**From:** Rich Elliott <elliotttr@kvfr.org>  
**Sent:** Wednesday, February 20, 2013 3:44 PM  
**To:** Jeff Watson; Dan Valoff  
**Cc:** Joe Seemiller; John Sinclair; Brenda Larsen; Bill Steele  
**Subject:** RE: Kittitas County Notice of Application

Jeff – The following is input/recommendations related to the Barnes Short Plat (SP-12-0008) on 4<sup>th</sup> Parallel Road. KVFR is not the authority having jurisdiction in this matter.

### [SP-12-00008 Barnes Short Plat Application](#)

BARNES SHORT PLAT KITTITAS COUNTY SHORT PLAT NO. SP-12XXXXX A PORTION OF THE NE 1/4 SECTION 5, TOWNSHIP 16 NORTH, RANGE 20 EAST, W.M., KITTITAS COUNTY, WASHINGTON

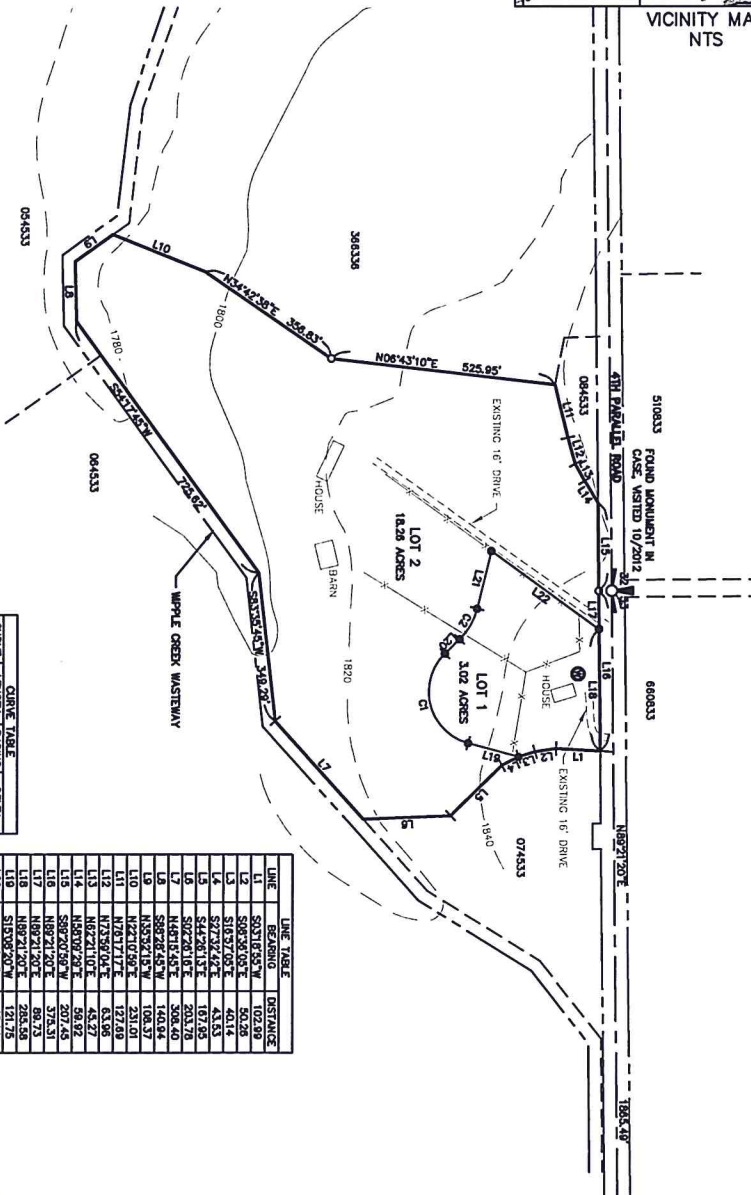
1. When the property is developed, the addresses need to be clearly visible from both directions of travel for all parcels.
2. Access to the property would need to be compliant with Appendix D of the applicable fire code at the time of development.
3. If adopted, a WUI Code assessment of the property will need to be completed and required mitigation performed prior to occupancy.
4. Water supply may possibly need to be addressed during development.
